Subject: A/3/21/PL - Further Engineers Comments Regarding Surface Water Drainage

Further Engineers Comments Regarding Surface Water Drainage

DRAWING TITLE:
PROPOSED
IMPERMEABLE AREAS
SHEET 2

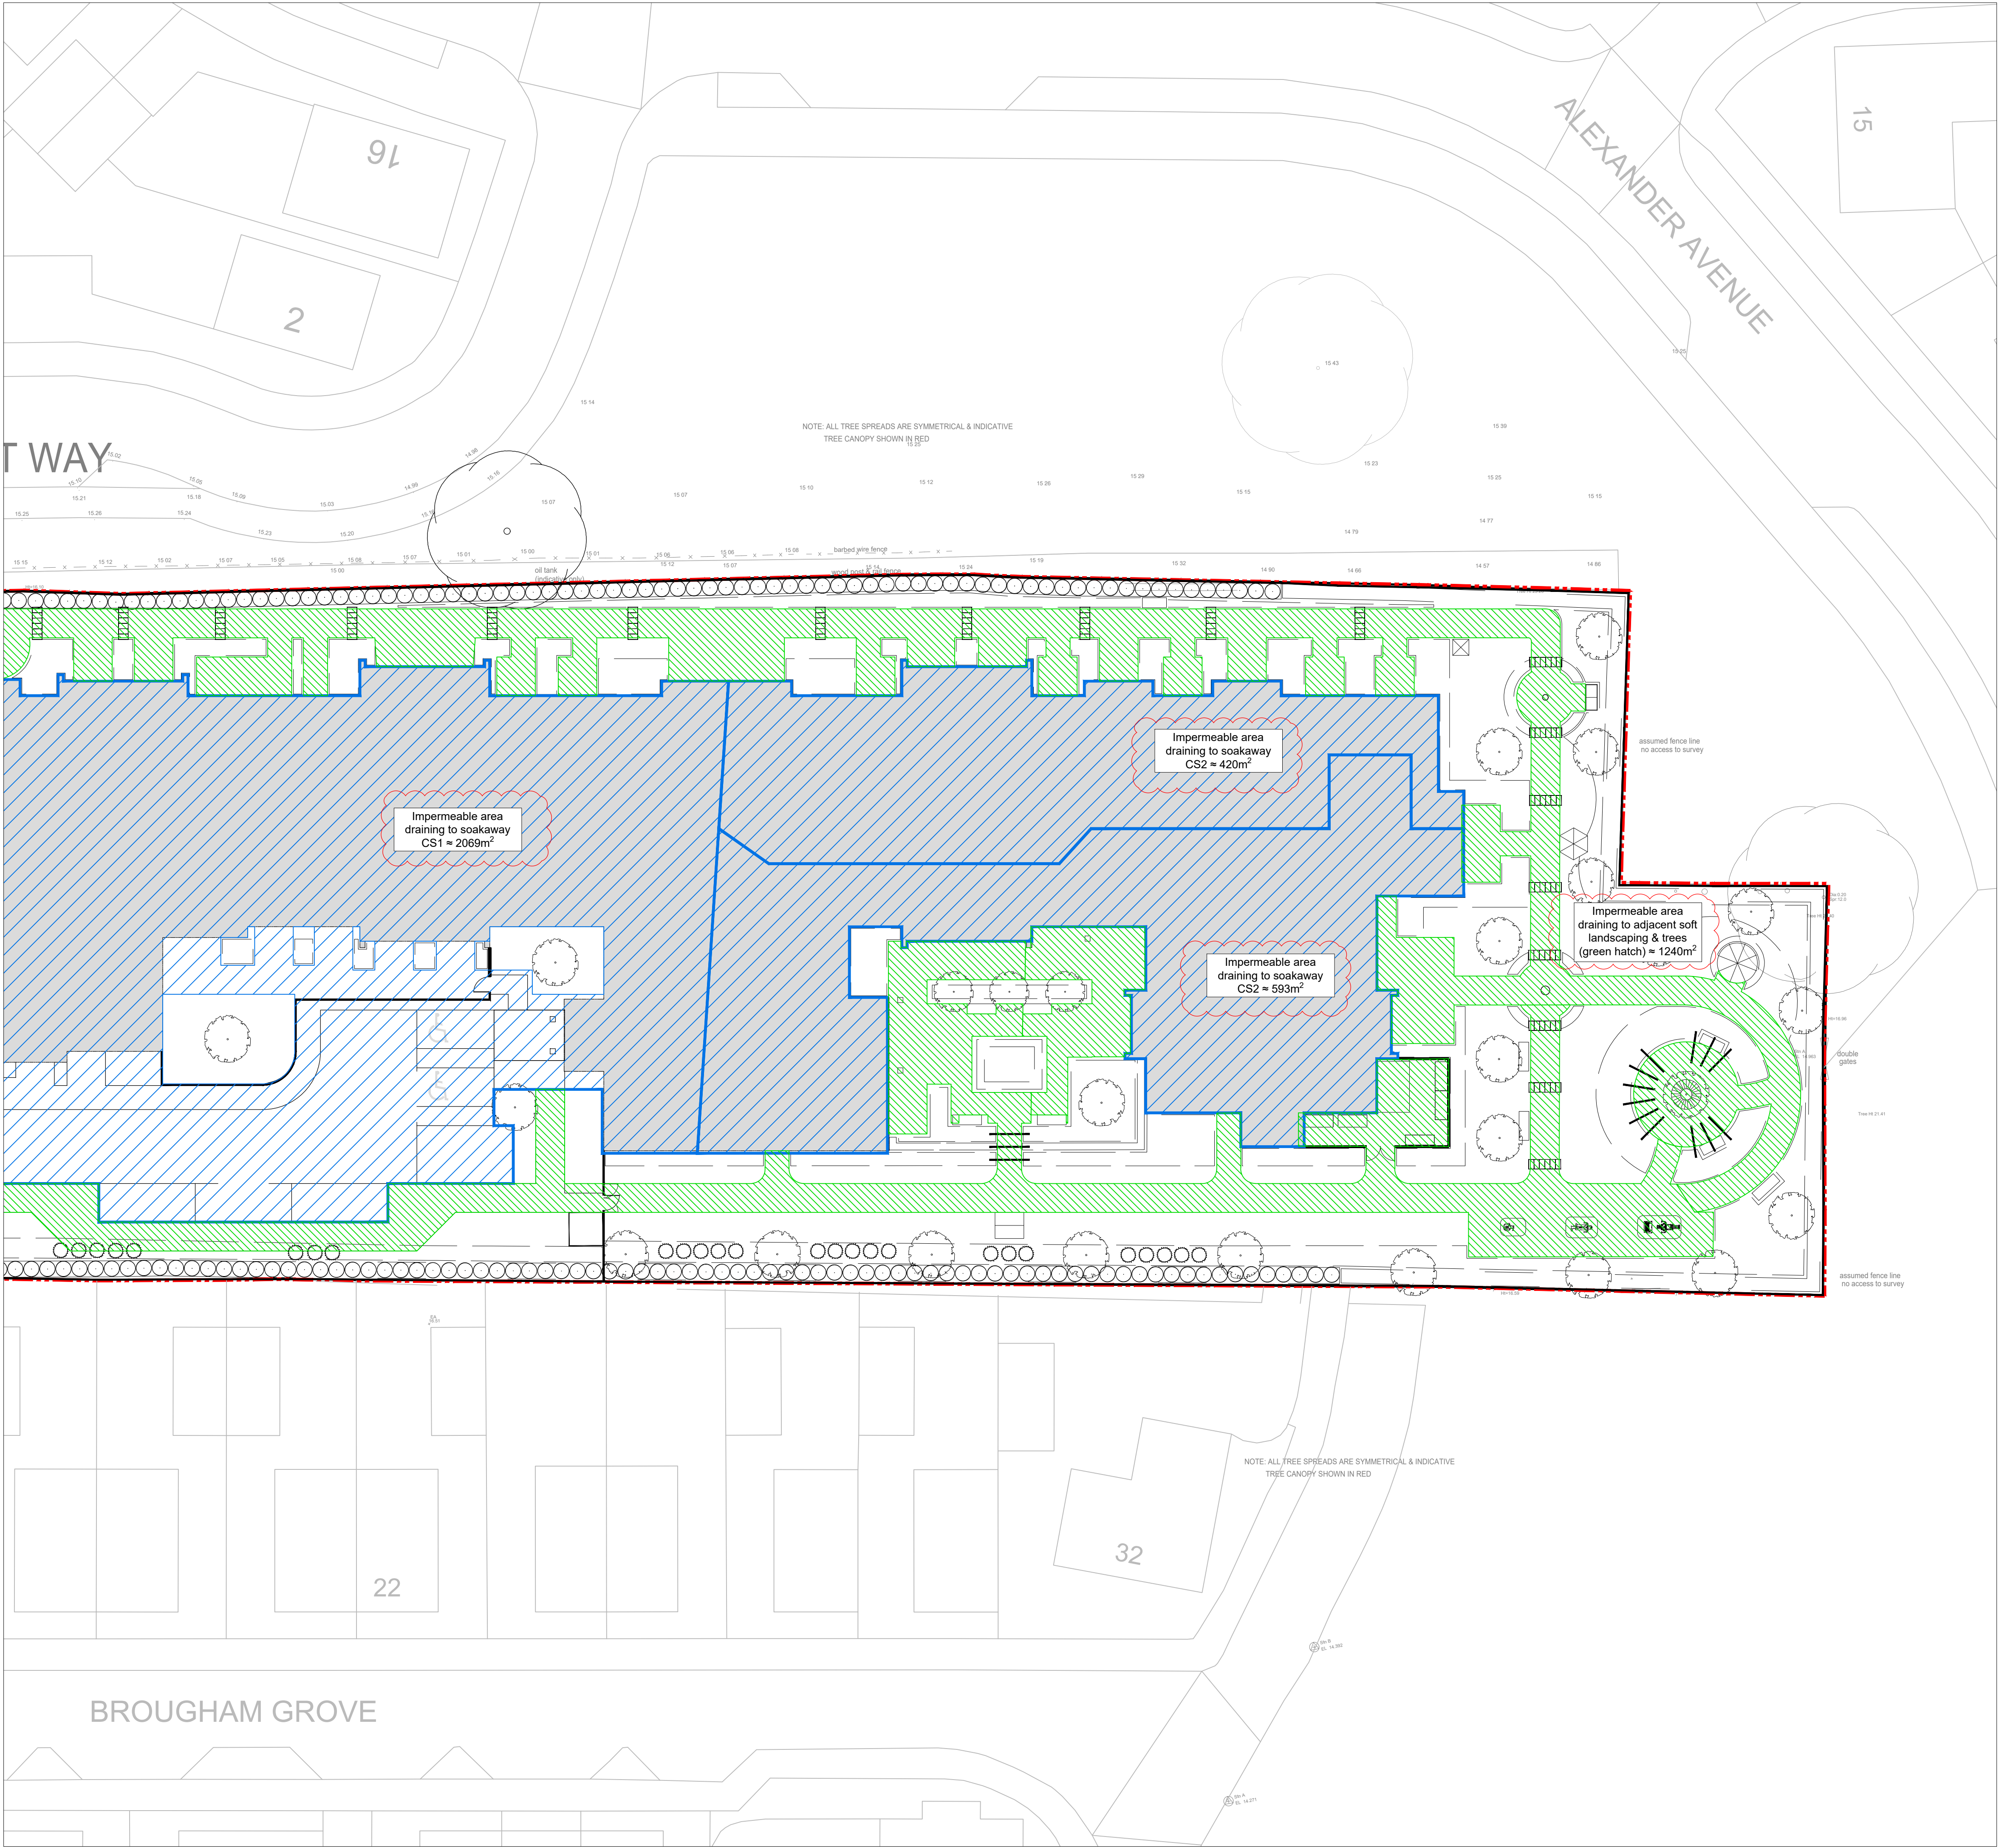
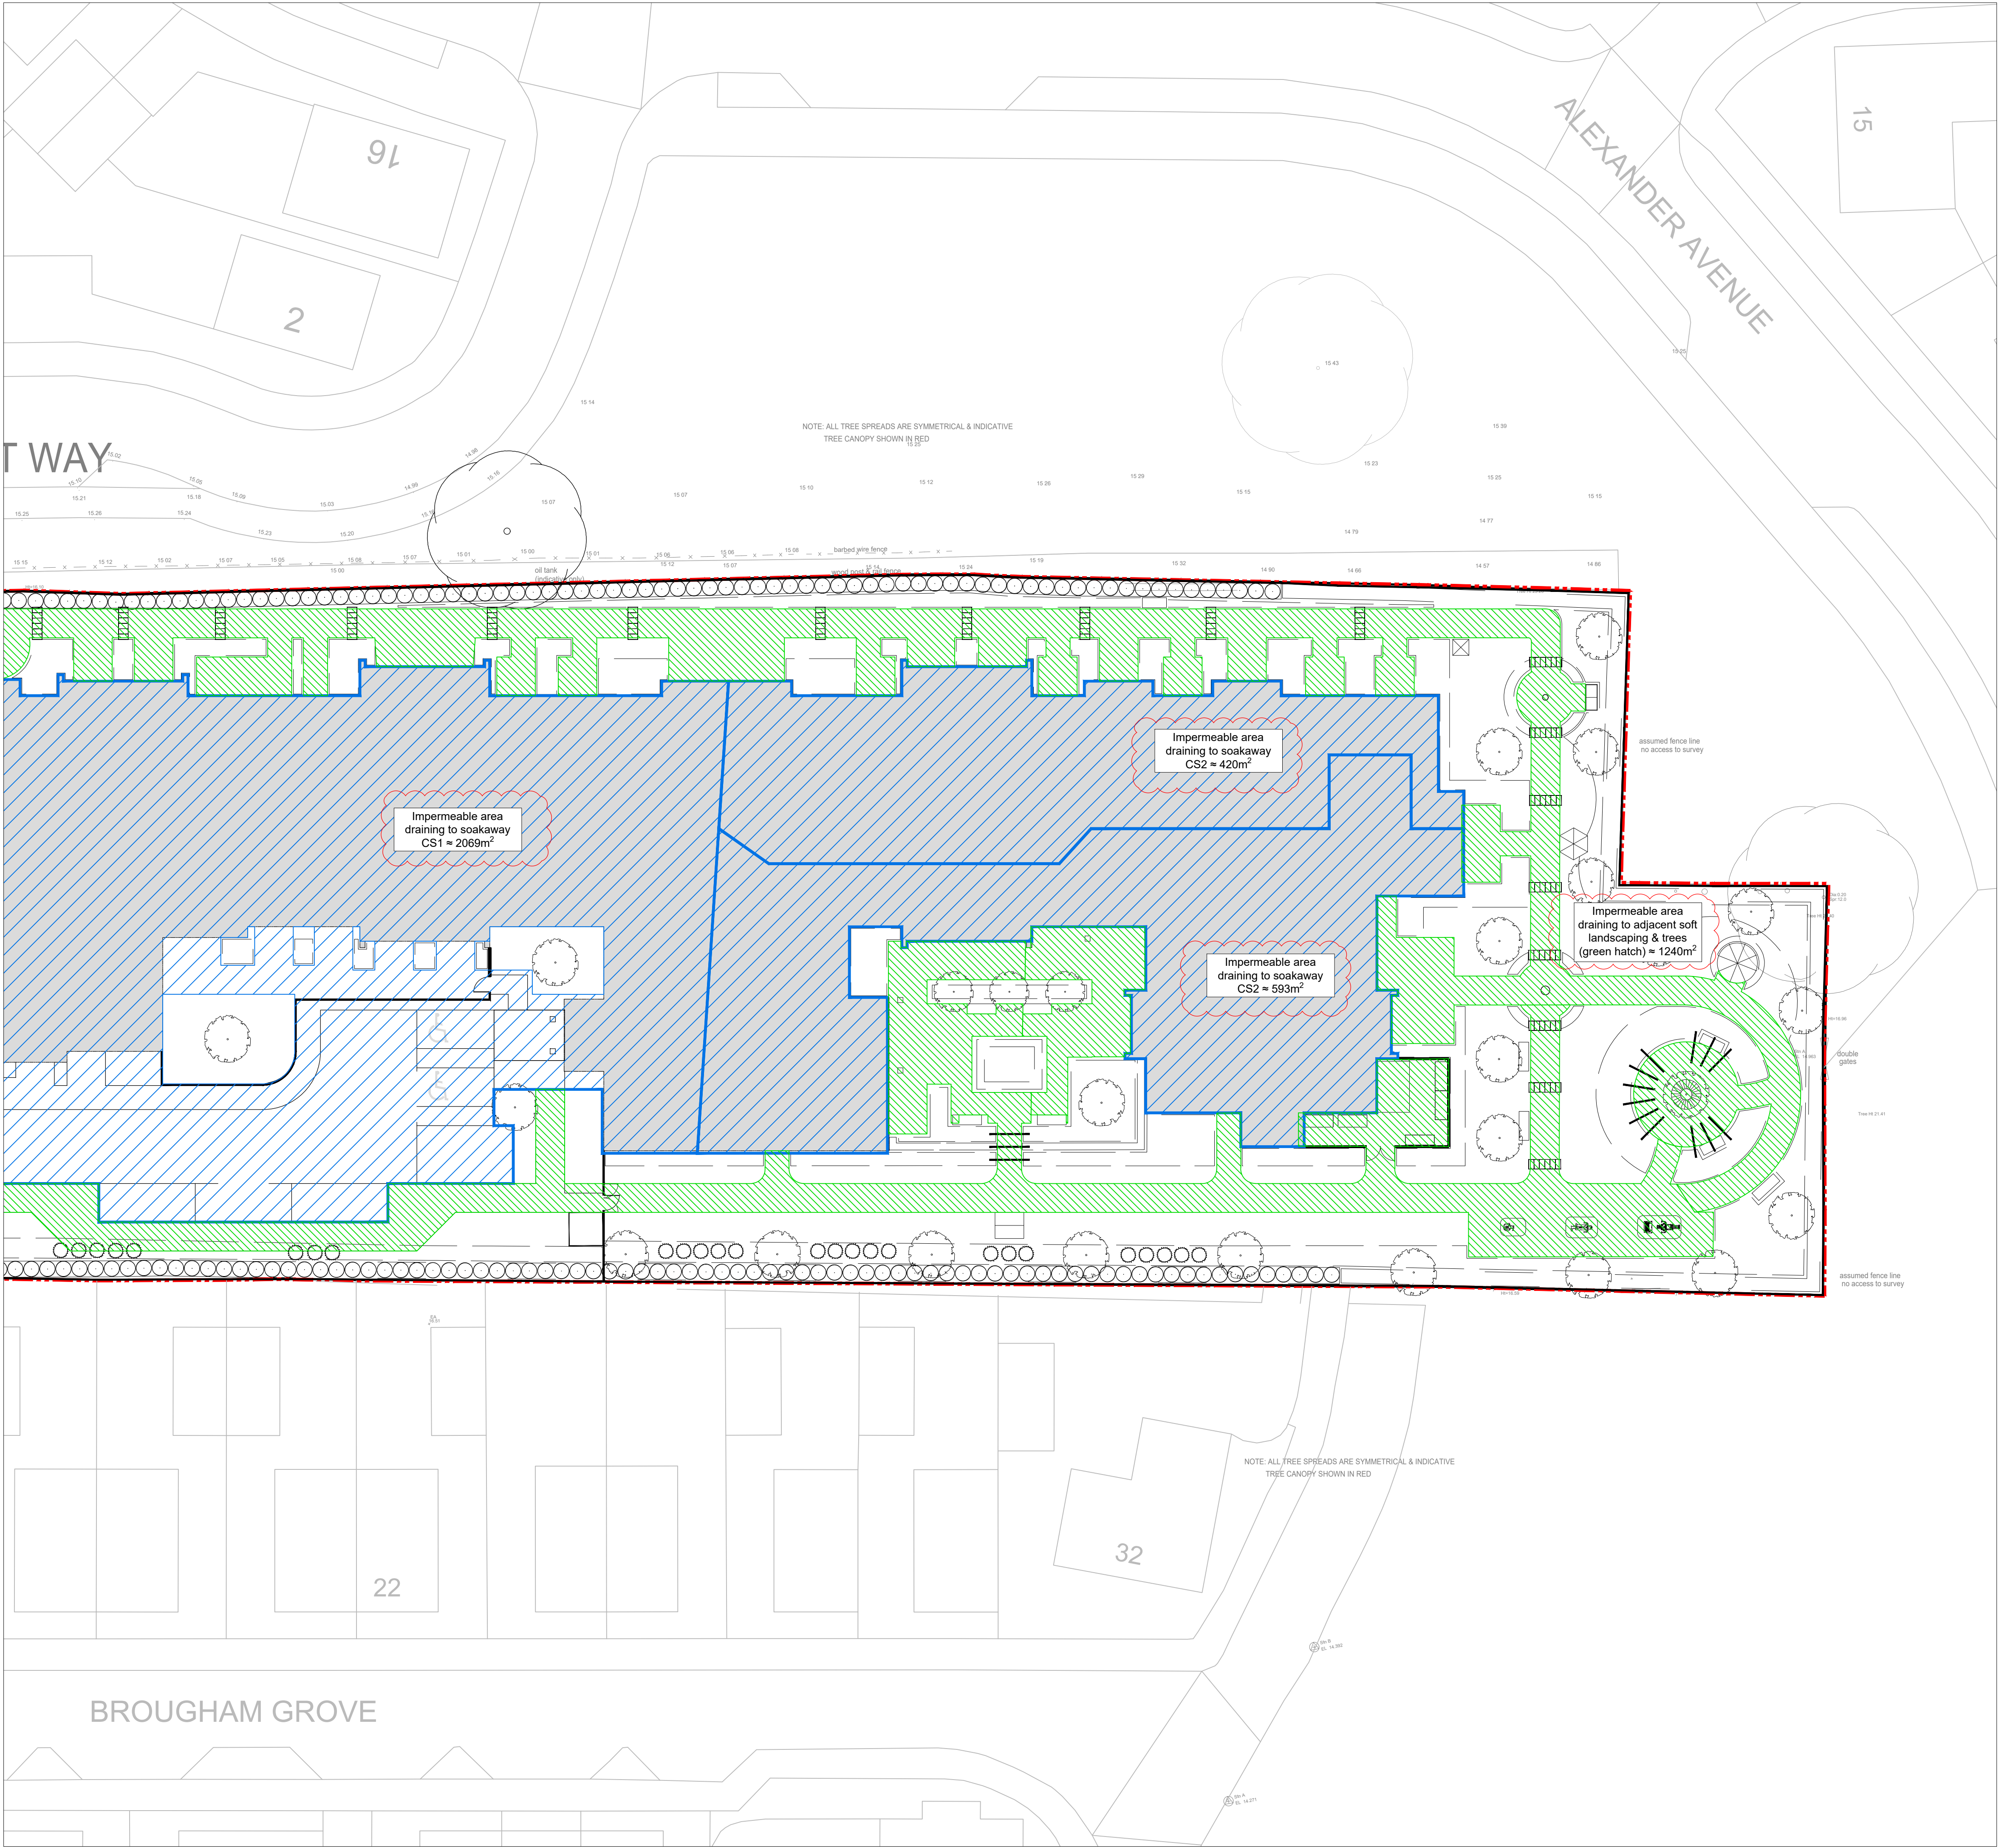
On the basis of the above, if you are minded to approve this application, please ensure that the Surface Water Drainage is constructed in accordance with the following plans:

Proposed Drainage Layout 64 Bed Sheet 1 3011 C06
Proposed Drainage Layout 64 Bed Sheet 2 3012 C07
Proposed Drainage Layout 64 Bed Sheet 3 3013 C07
Proposed Impermeable Areas Sheet 1 3500 P03
Proposed Impermeable Areas Sheet 2 3501 P03
Proposed Foul Water Manhole Schedule 3100 C05
